Consultation Response from: KC Environmental Health (Pollution & Noise Control)
2025/92886 13 Queen Street, Mirfield. WF14 8AH
Discharge of details reserved by conditions 5 (lighting), 6 (bird and bat box), 7 (electric recharging point), 8 (Remediation Strategy) on previous permission 2023/91383 for demolition of existing outbuilding and erection of two semi-detached dwellings
Date Responded:
16th June 2026

Condition 8 – Remediation Strategy

For the purpose of discharging condition 8 (Validation Statement), on previous permission 2023/91383, a Phase 4 Validation Report has been received written by Rogers Geotechnical Specialists (dated 29/05/2026 - C5162/26/E/9014).

Site Plan

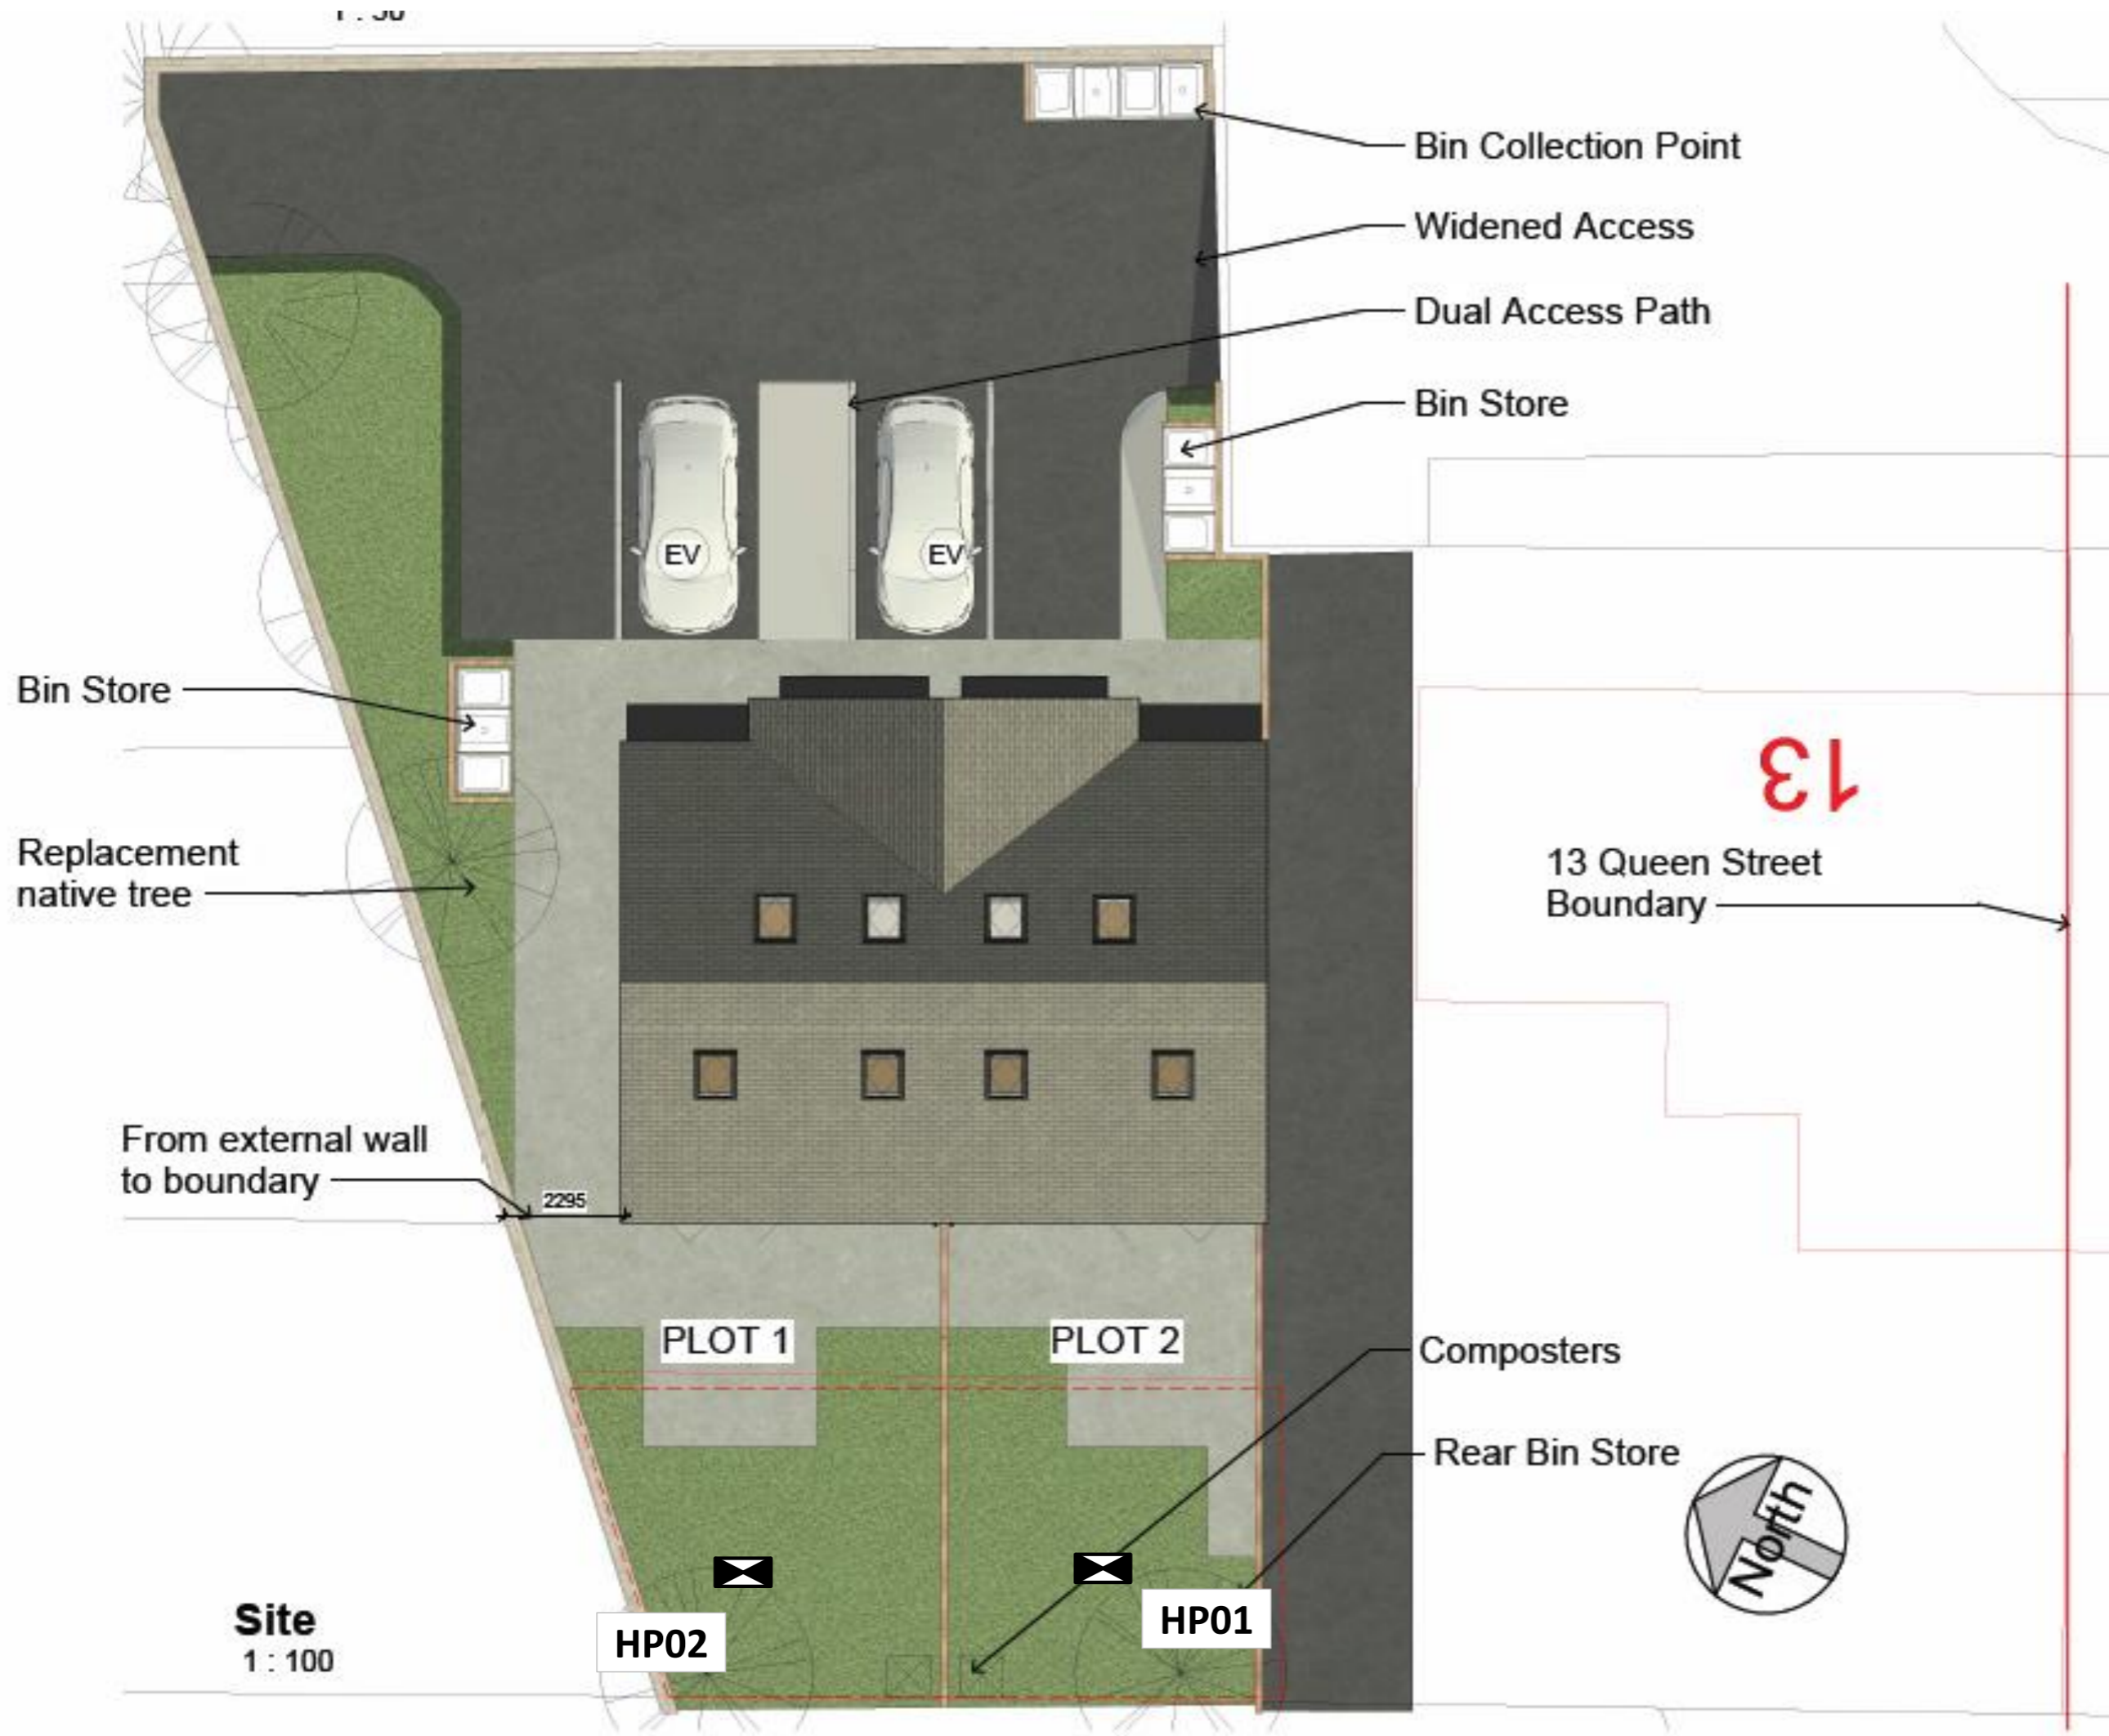
The sampling and testing regime of imported fill materials for supplementary quality control post placement is insufficient. Whilst four samples were collected, these were derived from only two trial pit locations, with a disproportionate number taken from a single location. It is also noted that an area of soft landscaping to the north of the site has not been subject to validation sampling. The limited number of sampling locations and lack of spatial coverage do not provide sufficient confidence that the cover system has been installed consistently across all garden areas. We would also expect this to extend to public open space so as to protect future occupants of the development from any potential land contamination and to accord with Policy LP53 of the Kirklees Local Plan and Chapter 15 of the National Planning Policy Framework.

In terms of verification of cover depth, the report demonstrates that a thickness of approximately 600mm has been achieved at the trial pit locations. Whilst this meets the specification set out within the remediation strategy for a clean cover system, the limited number of validation points means that continuity of this depth across all landscaped areas has not been demonstrated.
